# CITY OF ALBUQUERQUE

October 31, 2024

**Re: Nobis Rehab Hospital  
1100 Woodward PI NE  
Conceptual Traffic Circulation Layout for DFT Approval  
Engineer's Stamp 10-3-24 (J15D053)**

NOBIS REHAB HOSPITAL 1100 WOODWARD PL.	DRAWN BY pjm
	TRAFFIC CIRCULATION PLAN	DATE 1-29-26
1-29-26 RONALD R. BOHANNAN P.E. #7868	TIERRA WEST, LLC 5571 MIDWAY PARK PL NE ALBUQUERQUE, NEW MEXICO 87109 (505) 858-3100 www.tierrawestllc.com	SHEET # SP-1
		JOB # 2023123

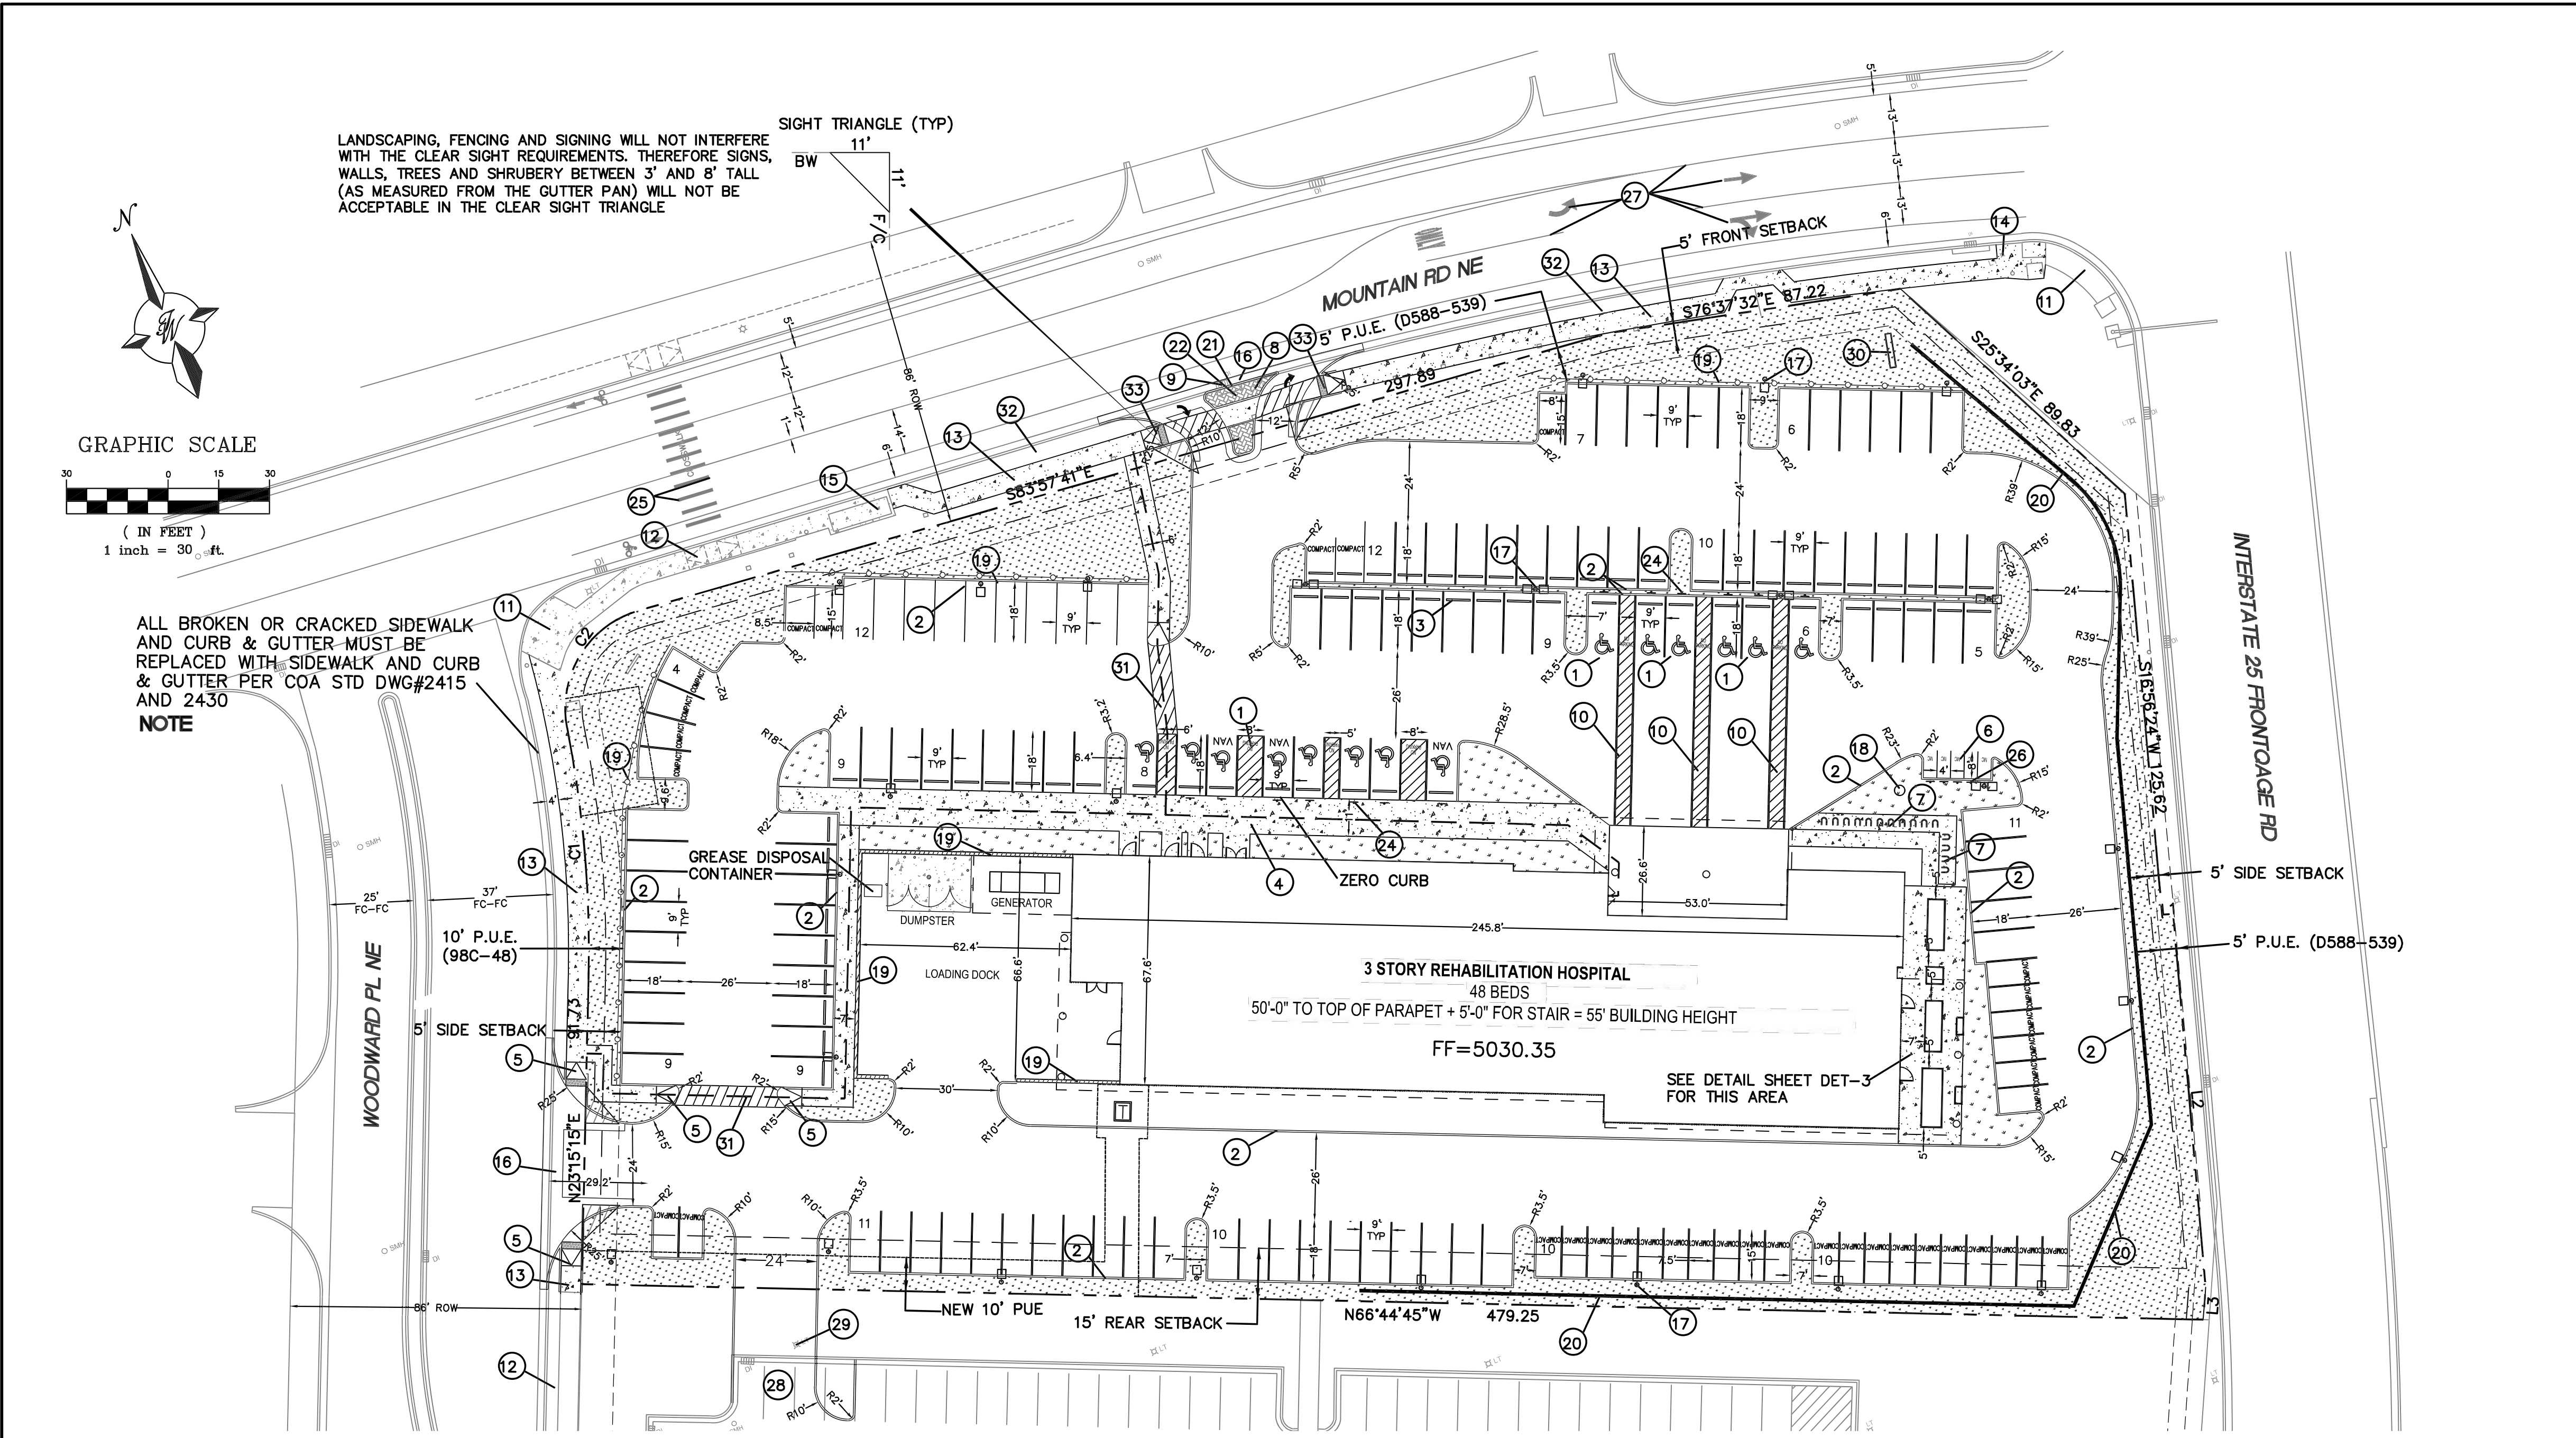
The conceptual TCL submittal received 10-17-2024 is approved for DHO and/or DFT submittal. When submitting this project through the building permit process, a full Traffic Circulation Layout will need to be submitted and approved prior to building permit. **When submitting TCL for building permit approval, please ensure that both site access details are provided and updated to meet the current ADA city standard.**
